# **SCOPING OPINION:**

## **Proposed A303 Stonehenge – Amesbury to Berwick Down**

**Case Reference: TR010025**

**November 2017**

Figure 2.8: Conceptual geology model - Cross section of tunnel

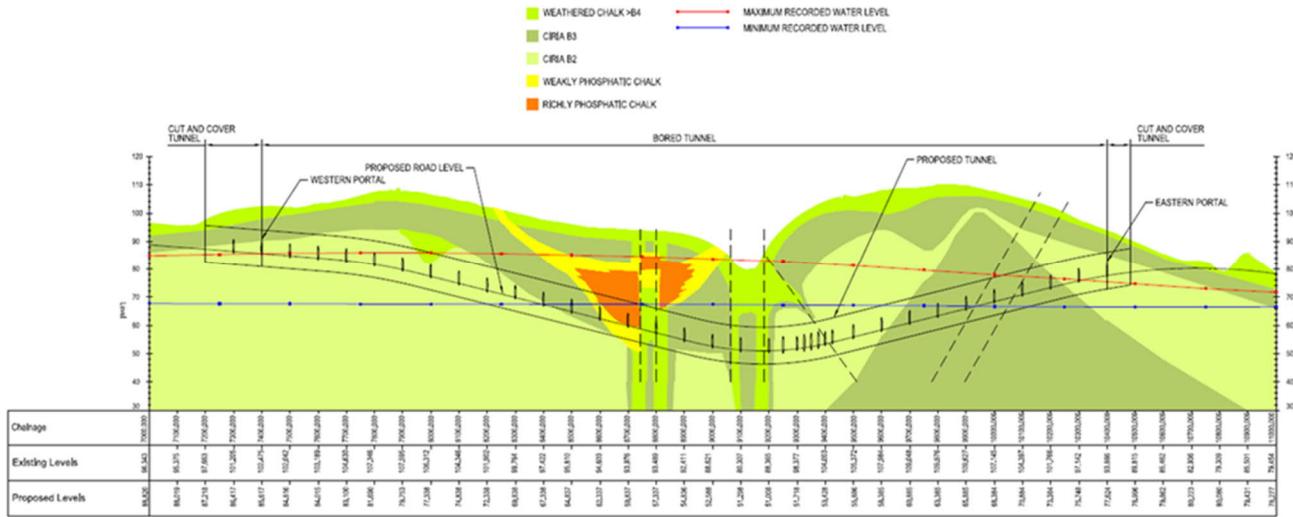
- 2.3.6 Paragraph 2.4.20 of the Scoping Report explains it is "*likely*" that a tunnel boring machine (TBM) would be used in the construction of the tunnelled section. Paragraph 6.7.22 of the Scoping Report also refers to uncertainty as to the type of tunnelling method to be used, although no specific references are made to any alternative tunnelling construction methods and the ES should account for any potential options that are being considered as part of the design of the Proposed Development. Section 3.3.2 states that "*Tunnel technology*" is being developed as part of the scheme design through autumn and winter 2017, but it is unclear if this relates to the methods of tunnelling or technology within the operational tunnel (or both).

**Figure 3.1: Option identification and selection process**

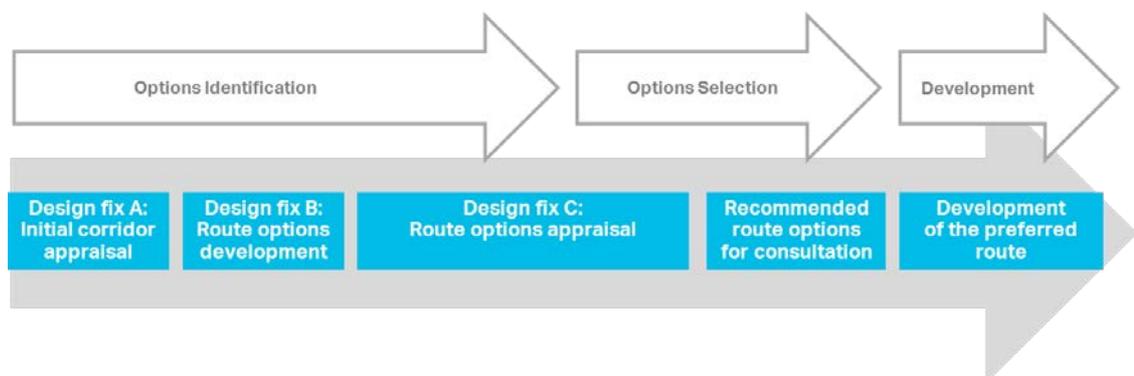
- 2.3.11 Section 3.2, Figure 3.1 and Table 3.1 of the Scoping Report describe the process of options identification undertaken by the Applicant to date, including consideration of 60 route options grouped into seven separate route corridors.
- 2.3.12 The ES should include a discrete section that provides details of the alternatives considered and the reasons leading to the chosen option(s), including a comparison of the environmental effects.
